11. ~~Project# 1007725~~
09DRB-70129 SKETCH PLAT REVIEW
AND COMMENT
GOLDEN AND ASSOCIATES LLC agent(s) for DIANE AND STEPHEN SLUSSER request(s) the above action(s) for all or a portion of Lot(s) 20-A-P1, Block(s) 2, **BUENA VISTA ESTATES UNIT 2** zoned R-D, located on RANCHO LADERA NE BETWEEN CORONA NE AND RANCHO MIRAGE NE containing approximately .1897 acre(s). (C-18)

DRB Comments

PROJECT # 1007725

RE: Lot 20-A-P1, Block 2, Buena Vista Estates Unit 2

# PLAT OF LOT 20-A-P1, BLOCK 2 BUENA VISTA ESTATES UNIT 2

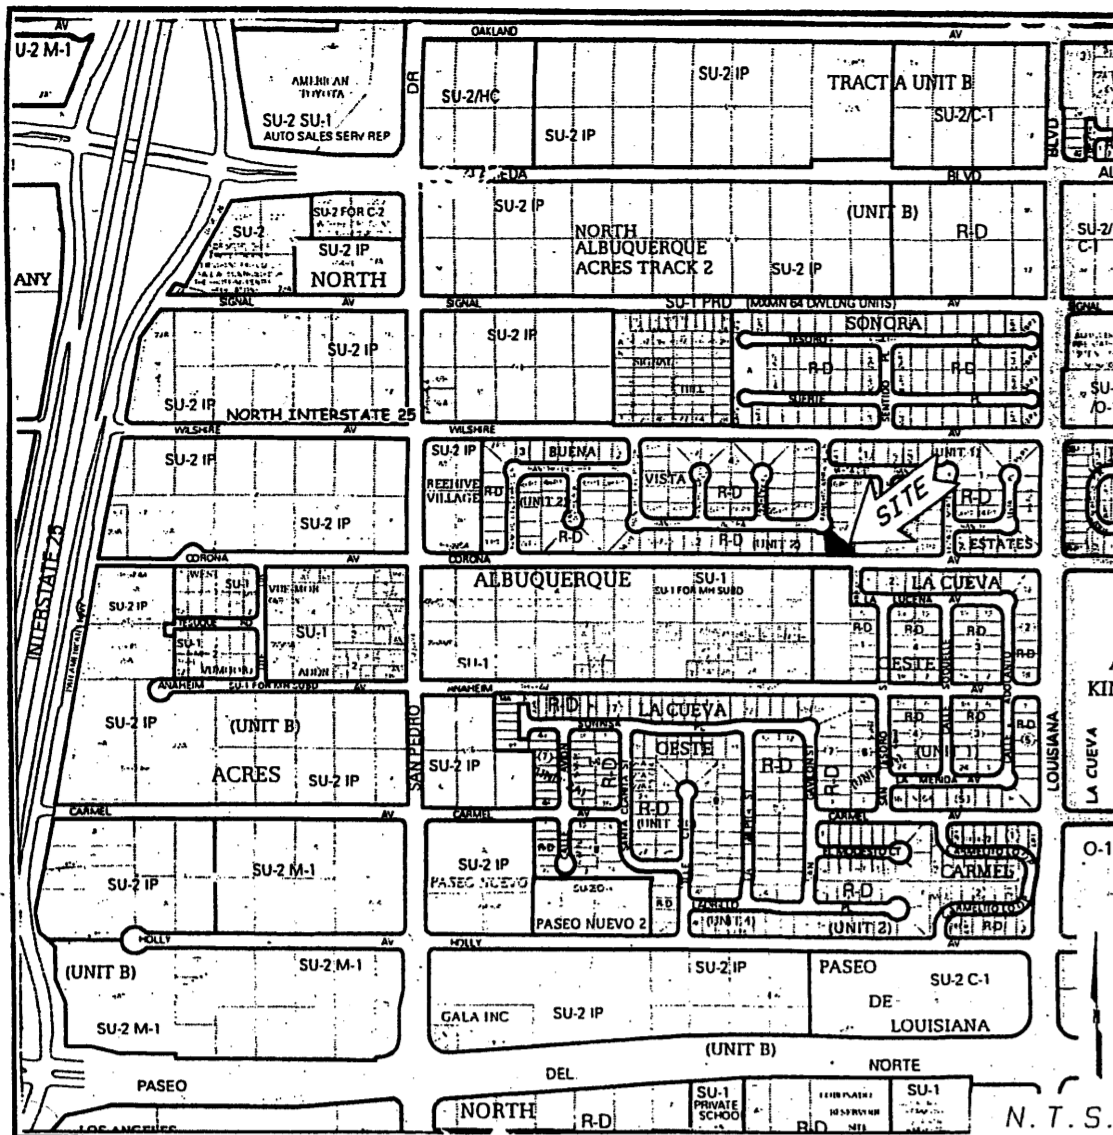
It would appear prudent to retain as much of the easement as possible, i.e. to vacate the minimum area.

Regarding the plat exhibit, current signatures (dated in 2009) will be needed.
